# Comment for planning application 21/03164/OBL

| <b>Proposal</b>           | <input type="text" value="Discharge of golfing obligations associated with the Second Schedule to the Great Wolf Resort s106 (19/02550/F)."/> |

## Planning Application - 21/03164/OBL

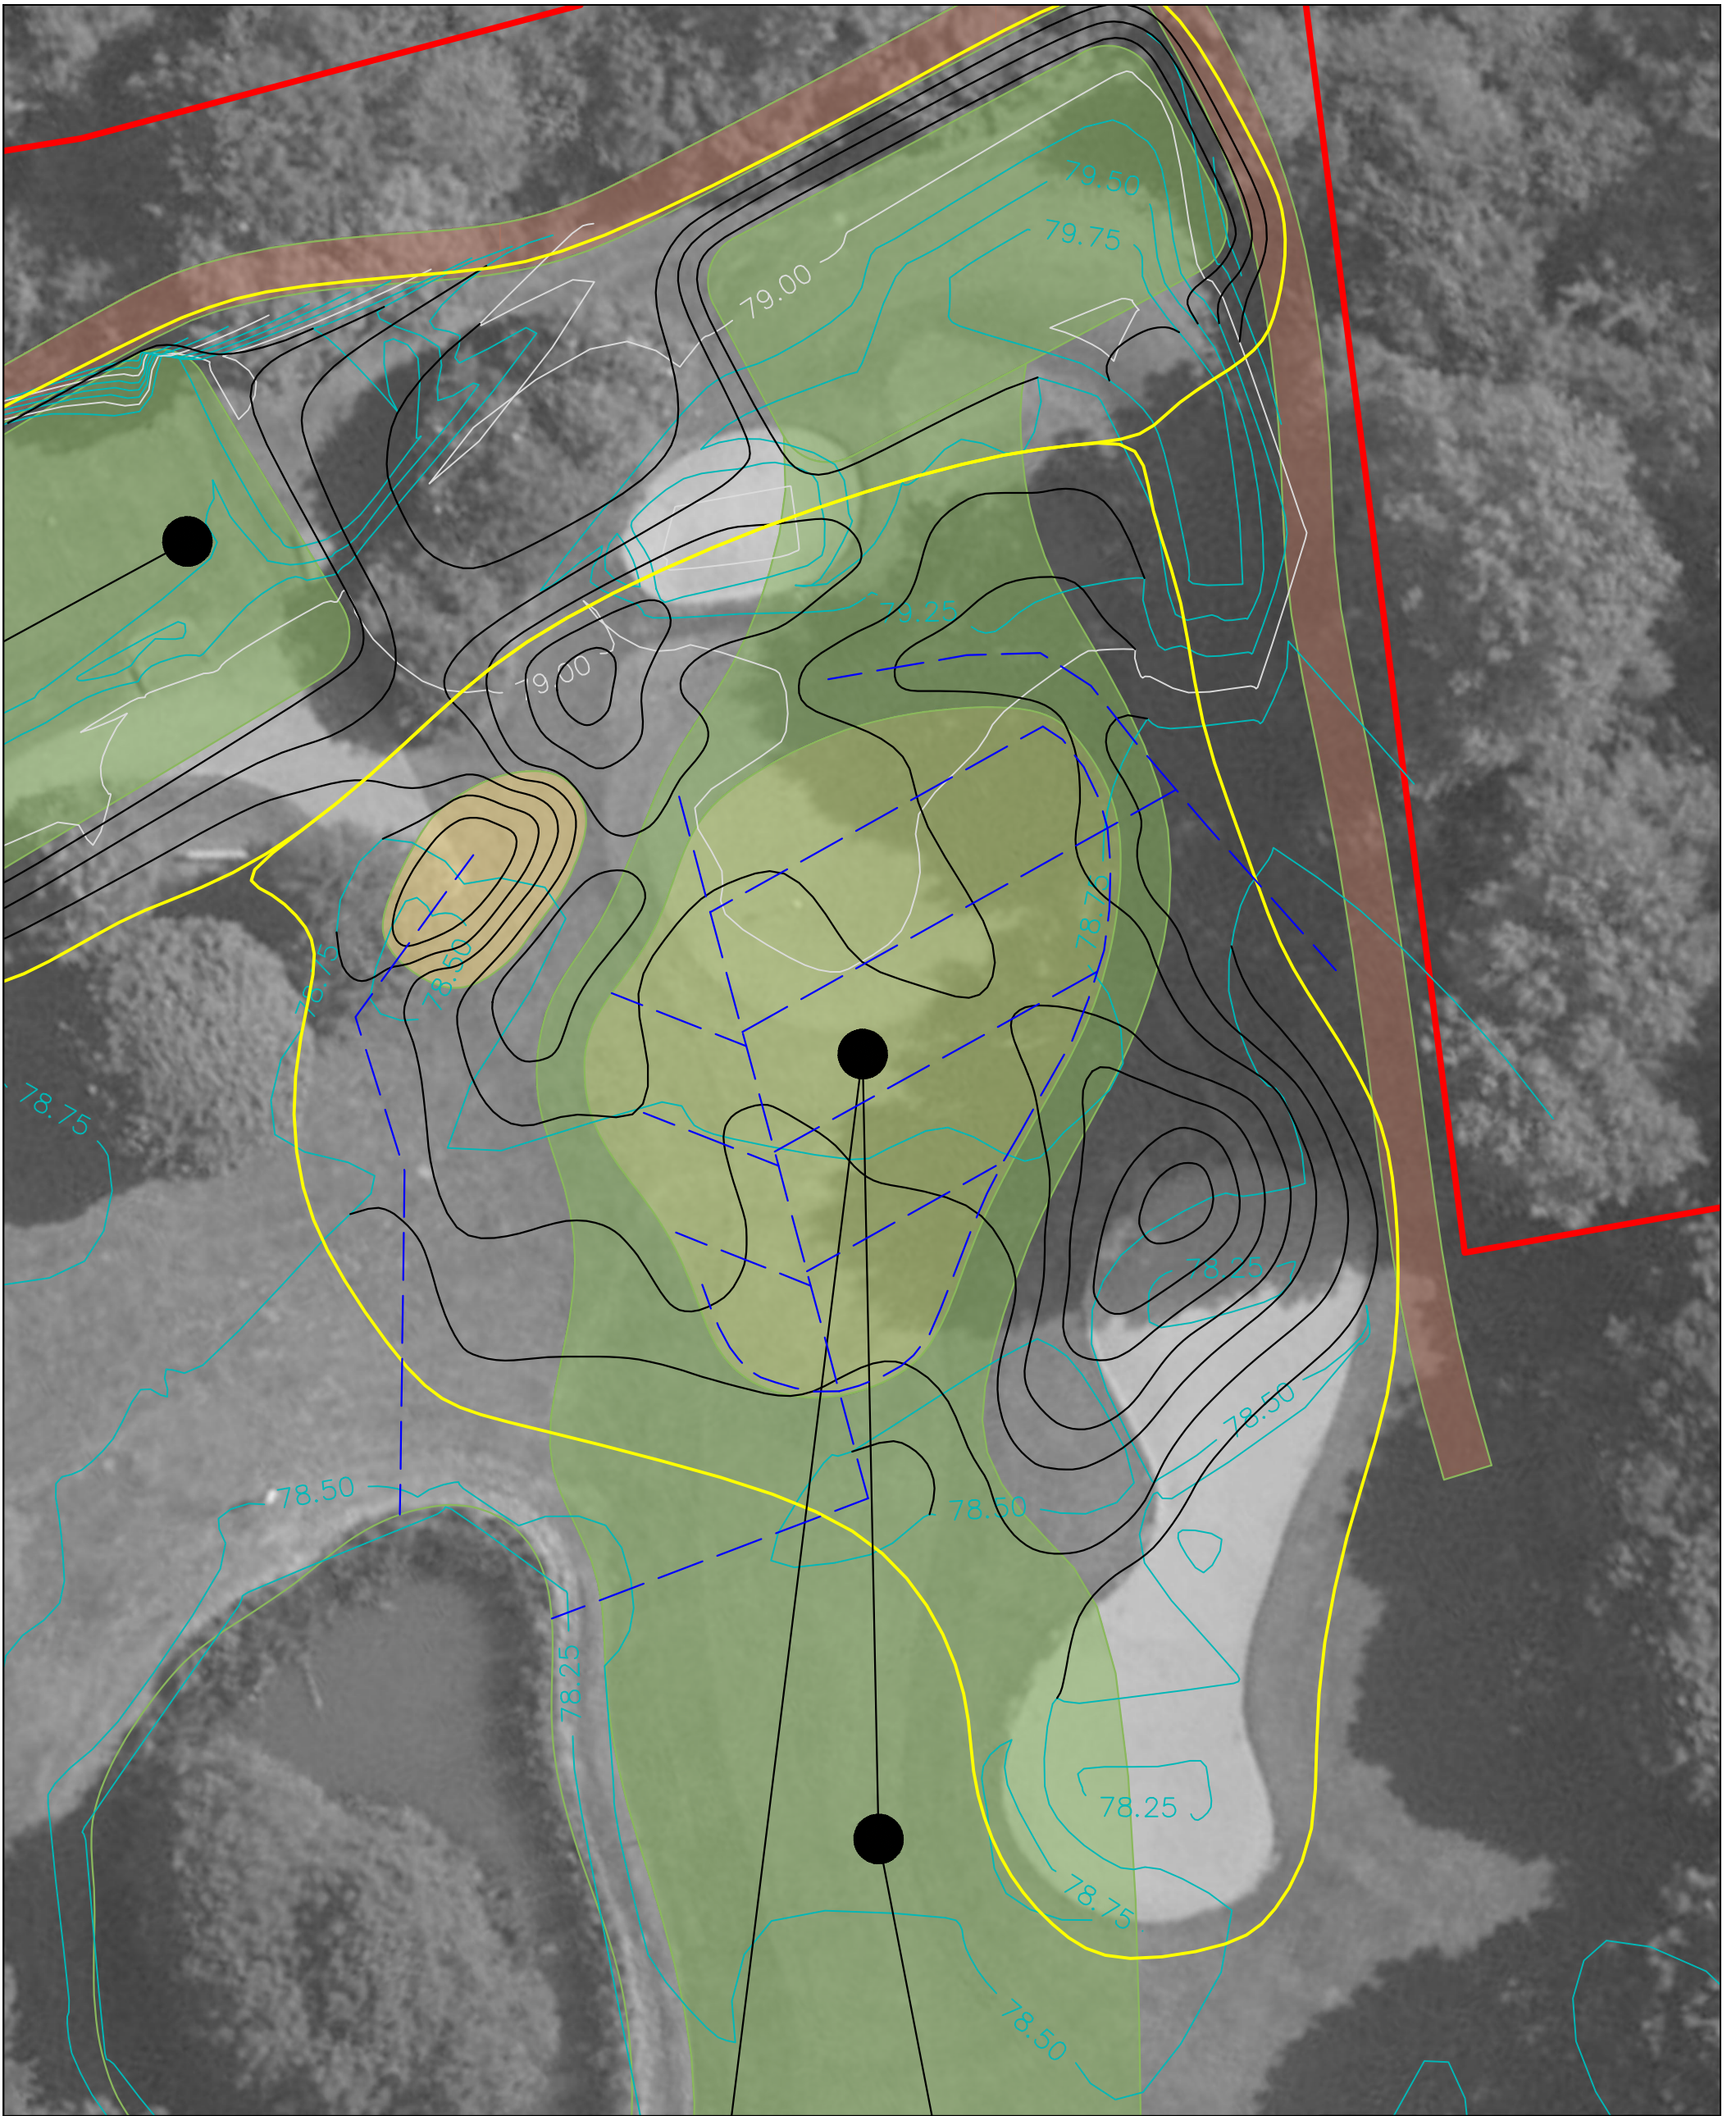
I am concerned that golfers will be vulnerable to being hit by thinned golf balls from golfers approaching the new 4<sup>th</sup> Green. Will there be a protective fence built?

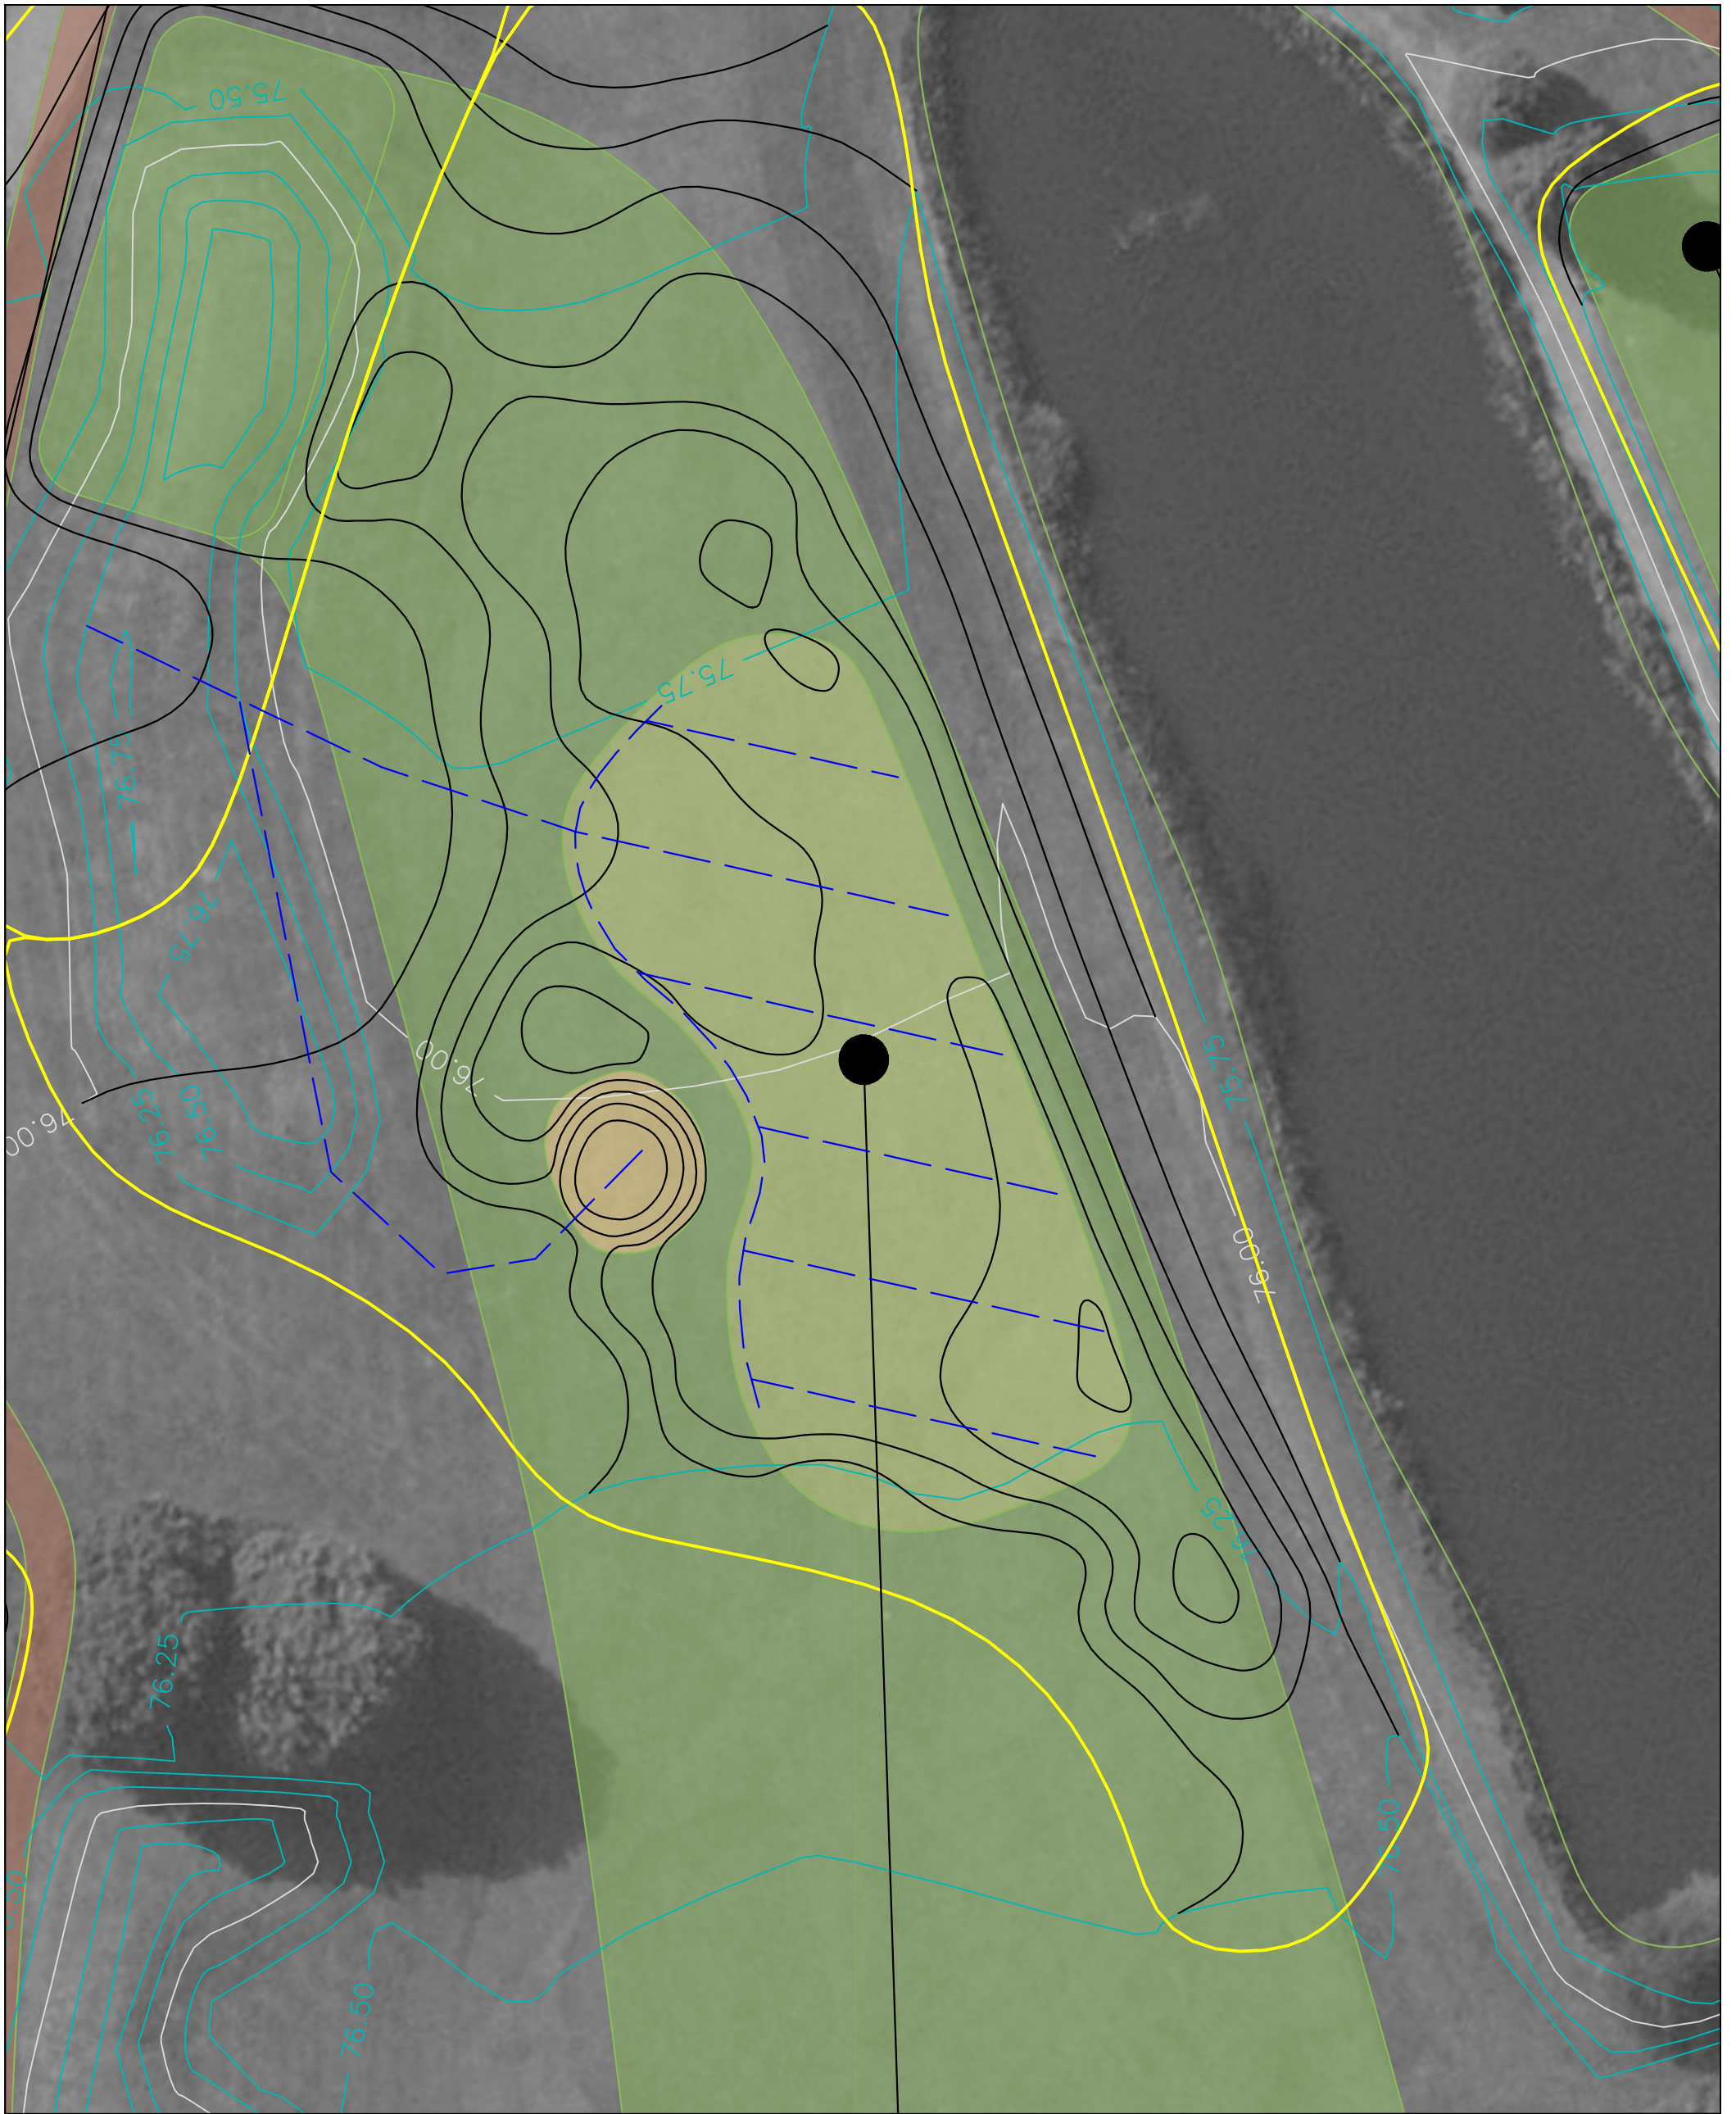
There is a very serious risk that golfers putting or approaching the new 8<sup>th</sup> green, will not be safe from those driving off the new 5<sup>th</sup> tees and the new 9<sup>th</sup> back tee (present 4<sup>th</sup> Green). In the event of someone on the 8<sup>th</sup> green being hit by an errant golf ball, who would be responsible if someone is seriously hurt and the case ends up in litigation? Is it the golfer

I have two other points to make on the new 8<sup>th</sup> Green and new back 9<sup>th</sup> tee positions.

The new 8<sup>th</sup> green is far too close to the water for the average golfer to be a fun hole. It will be a long iron or wood shot into the green and especially when the fairway is baked hard in the summer many approach shots will end up in the water.

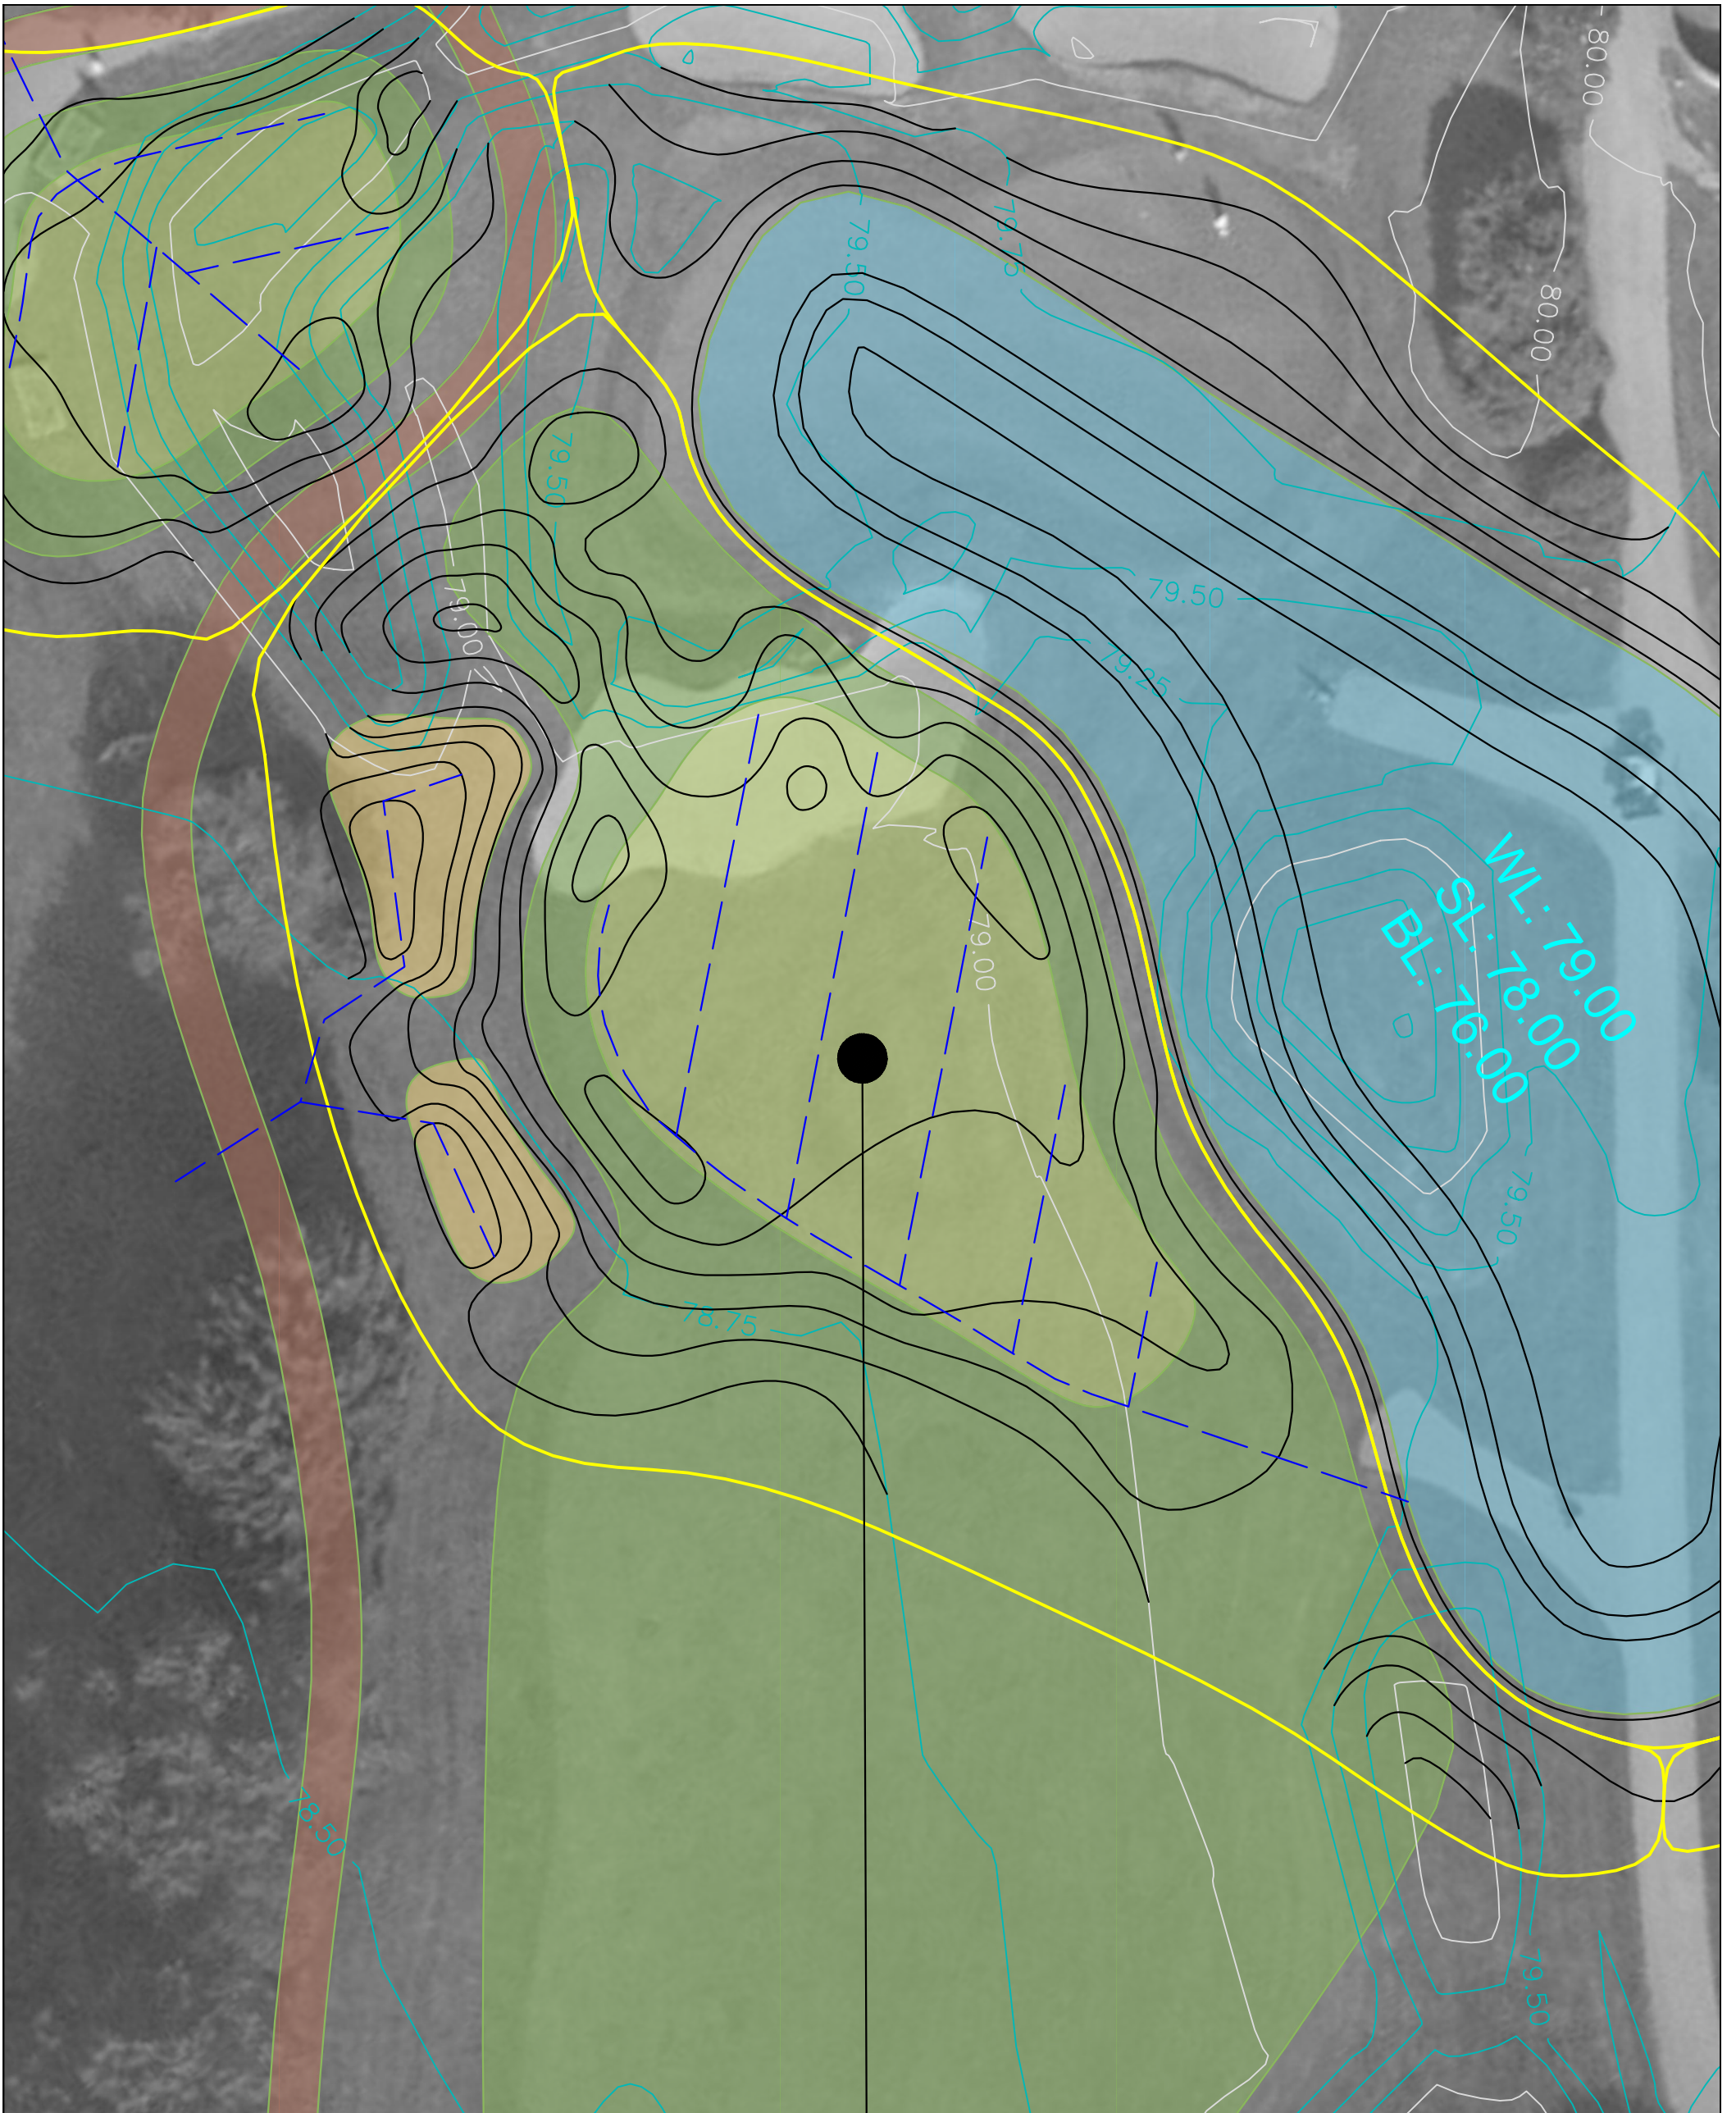
The new back tee position on the new 9<sup>th</sup> will be difficult for many seniors and others, as it is too far to drive over the water.
